WEST SUSSEX COUNTY COUNCIL CONSULTATION

TO:	Arun District Council FAO: Mrs A Gardner
FROM:	Highways, WSCC
DATE:	04/01/2019
LOCATION:	Cherry Tree Nursery, Eastergate Lane, Eastergate, BN18 0BA
SUBJECT:	WA/108/18/PD Notification for Prior Approval under Class Q for a Proposed Change of Use of Agricultural Building to 5 No. Dwellinghouses (Class C3) & associated works.
DATE OF SITE VISIT:	04/01/2019
RECOMMENDATION:	☒ Advice ☐ Objection ☐ Modification ☐ No Objection ☐ More Information ☐ Refusal
S106 CONTRIBUTION TOTAL:	£N/A

Drawing 8 – Proposed Site Plan
Scale 1:200 @ A2

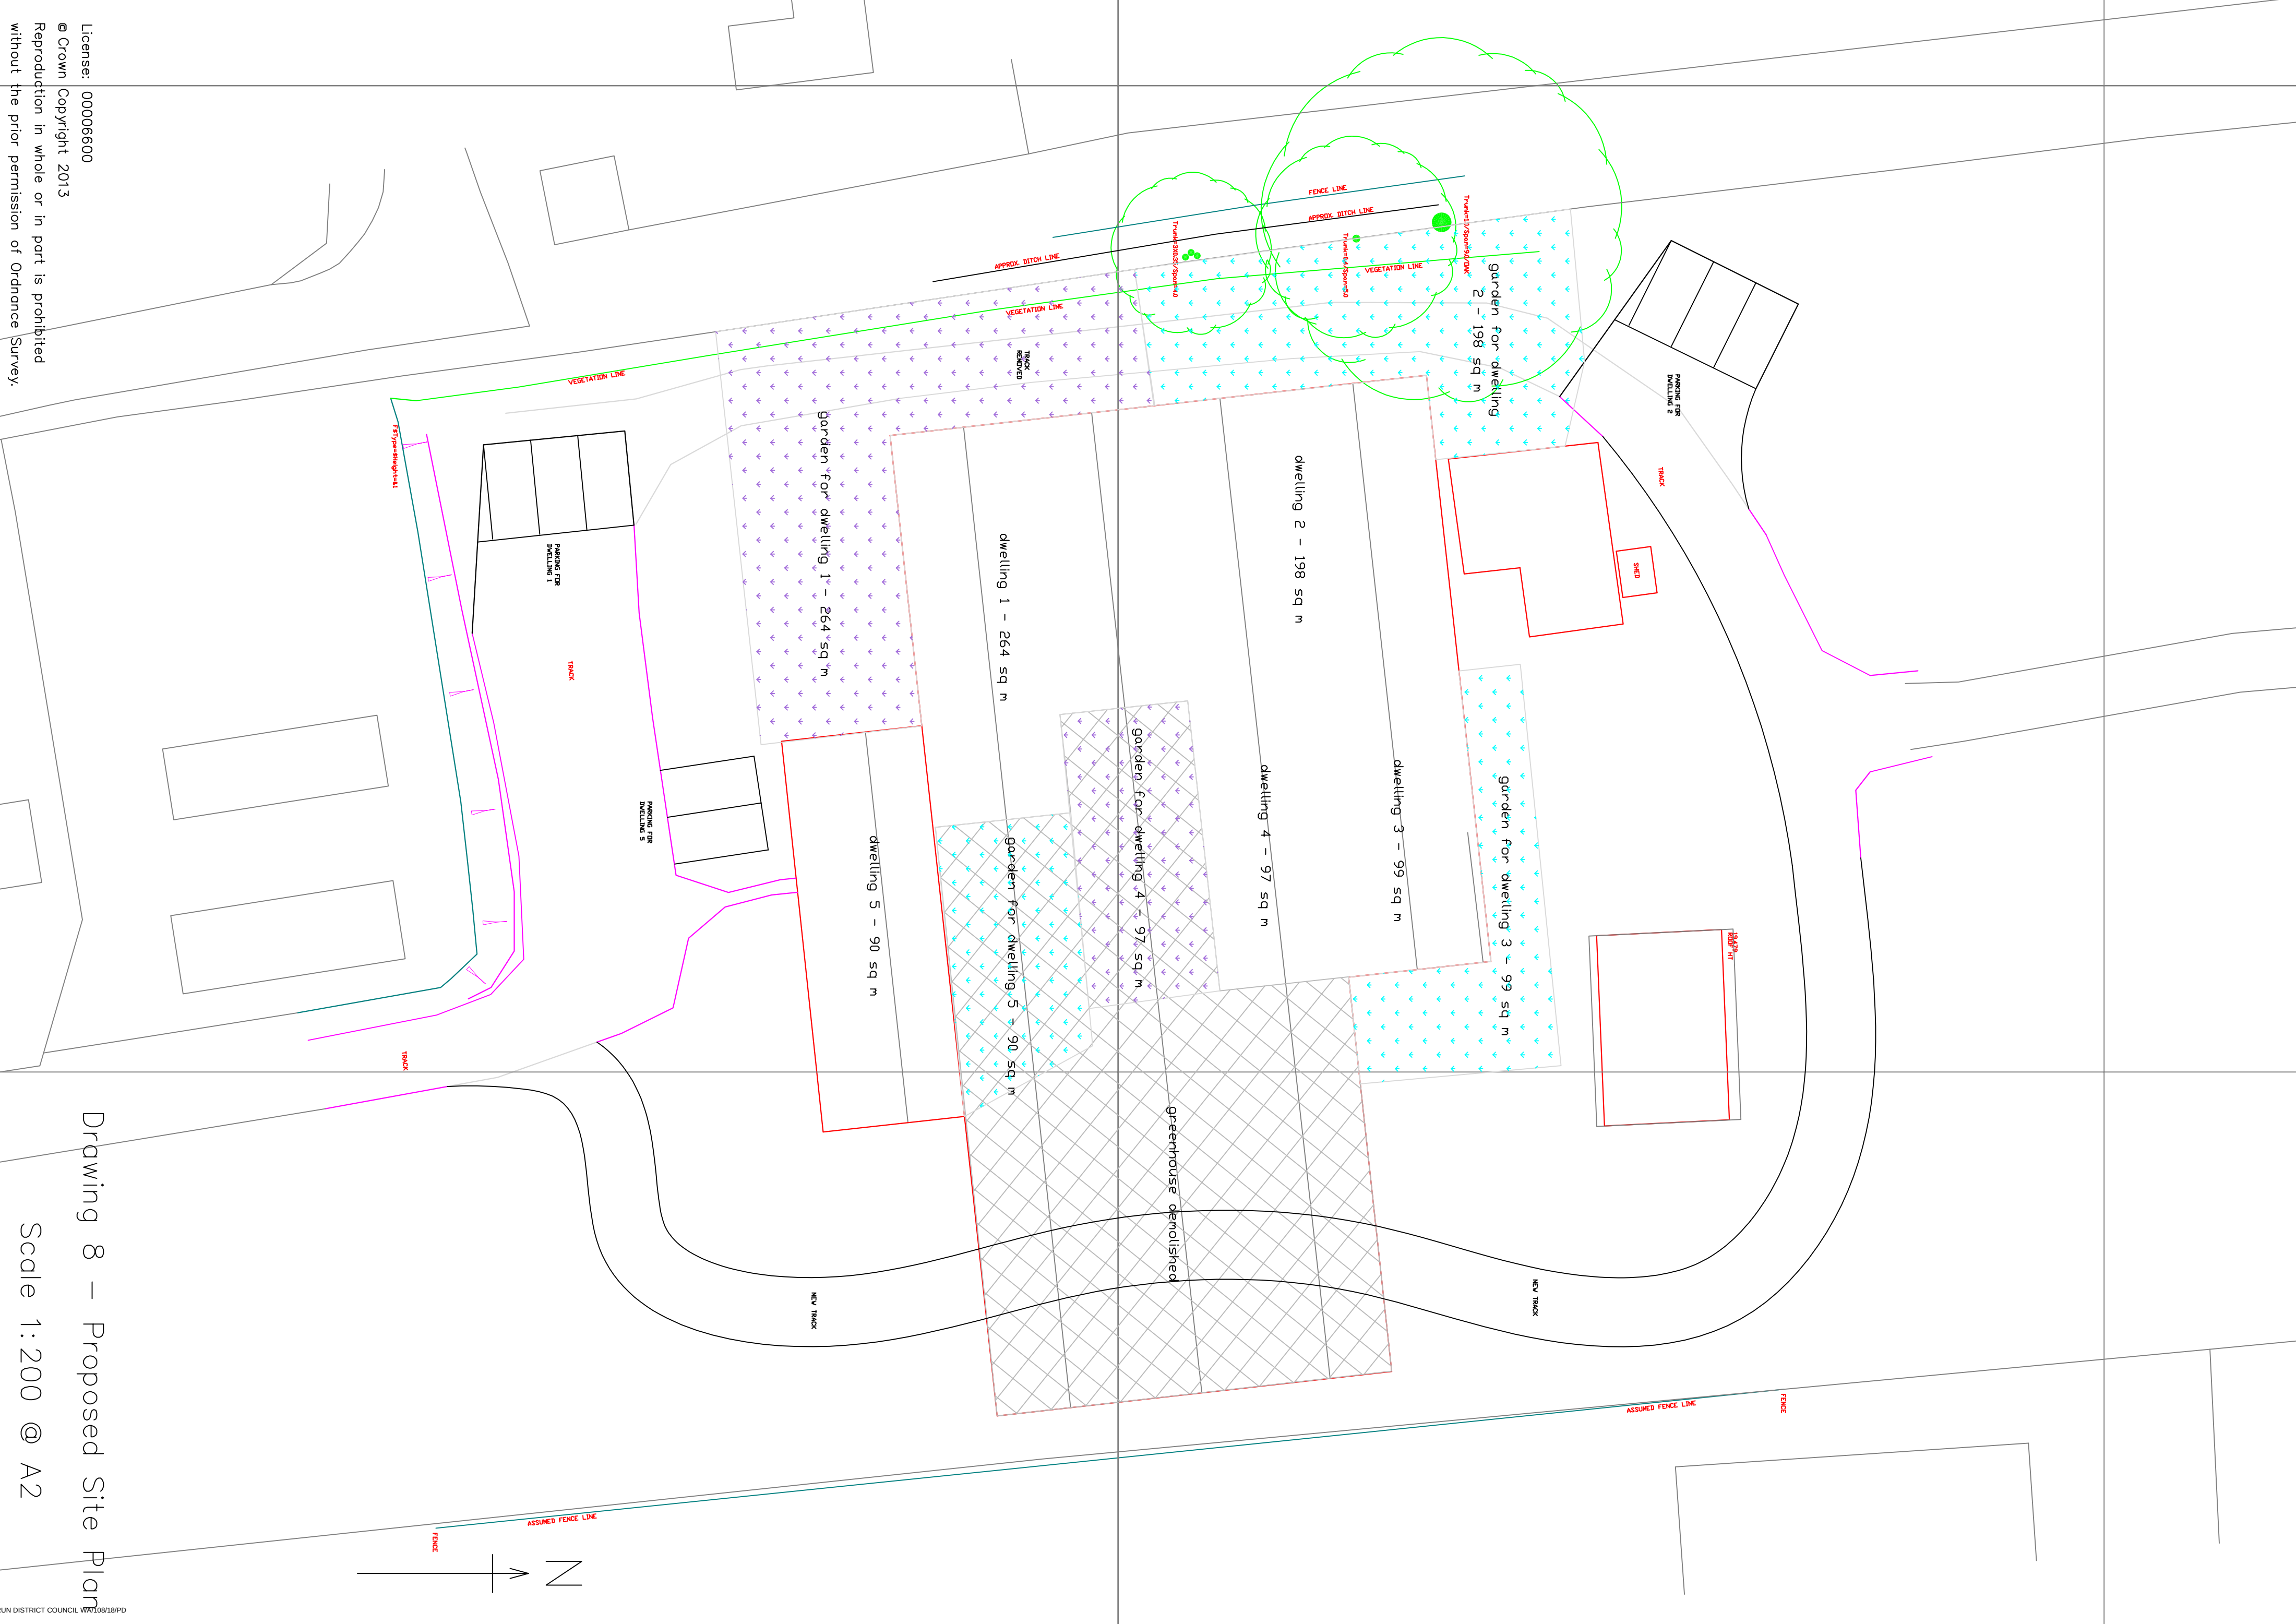
8 Parking spaces are proposed to serve the development, it is unclear whether these are allocated, however on the basis that they are unallocated the 8 parking spaces are considered to meet the demand generated by the proposal. Overspill parking would not be anticipated to occur on Eastergate Lane due to the length of the access road from the highway to the site and the nature of the highway at this point.

No part of the development shall be first occupied until the car parking has been constructed in accordance with the approved site plan. These spaces shall thereafter be retained at all times for their designated purpose.
